**From:**  
**Sent:** Thursday, May 25, 2023 1:12 PM  
**To:** Wellbeing <[Wellbeing@Cherwell-DC.gov.uk](mailto:Wellbeing@Cherwell-DC.gov.uk)>  
**Subject:** planning for housing in Sibford Ferris

Your Ref: 23/01316/F

**Erection of 5 two storey age restricted dwellings (55 years) for older people with access, landscaping and associated infrastructure - Land South of Faraday House, Woodway Road, Sibford Ferris (Application No. 23/01316/F)**

**Figure 4 – Proposed Site Plan**

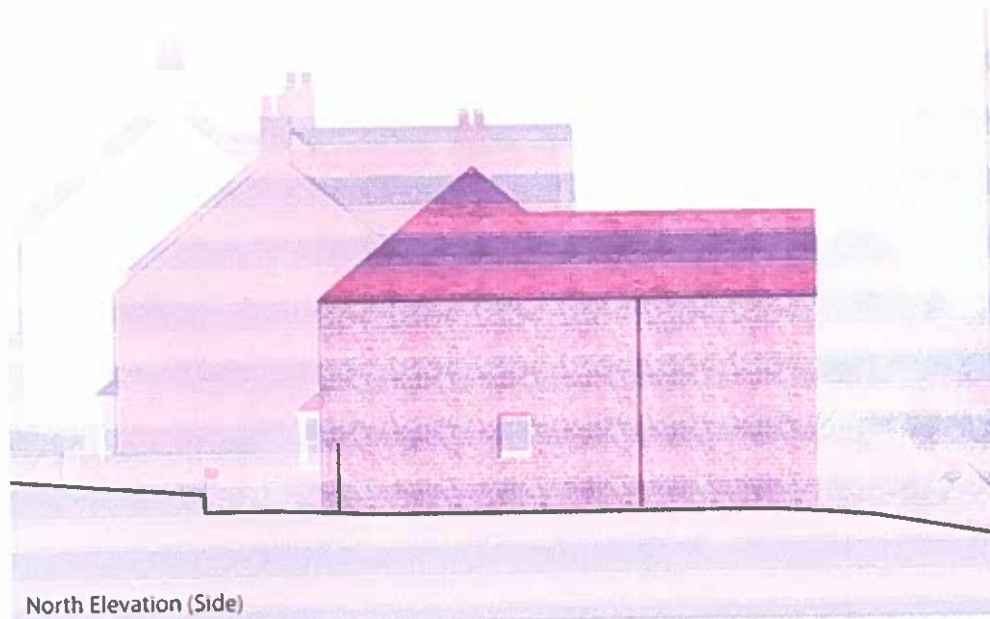
The close proximity of the proposal to existing dwellings is evident from Figure 4.

Figure 6 – View of Proposal from the North (Faraday House)

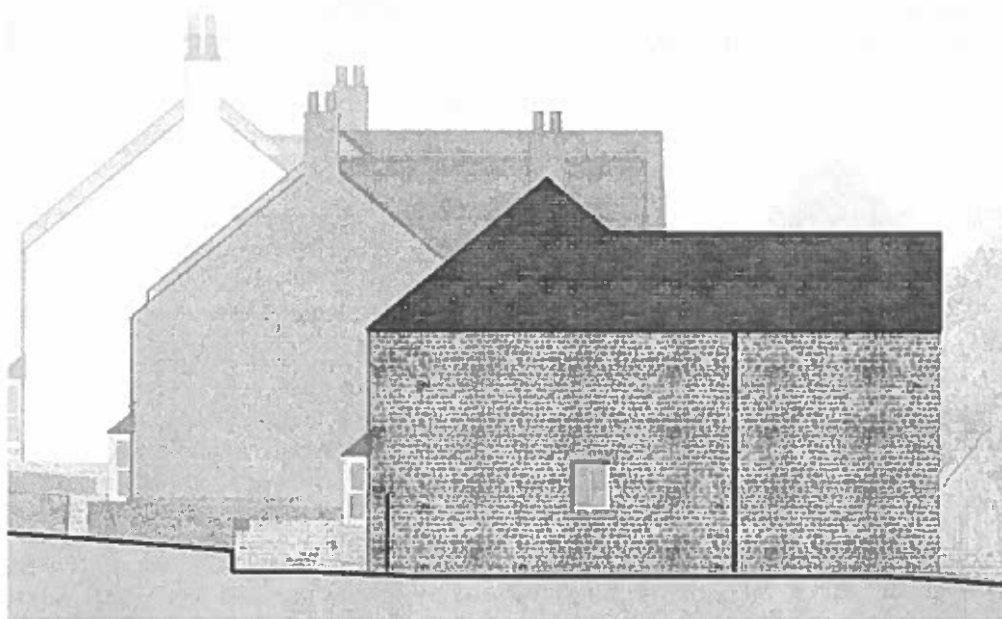
The physical impact of the dwellings – especially Plot 5 – is perhaps most acute upon Faraday House just 15 metres to the north of the site, as shown on Figure 6 taken from the application.
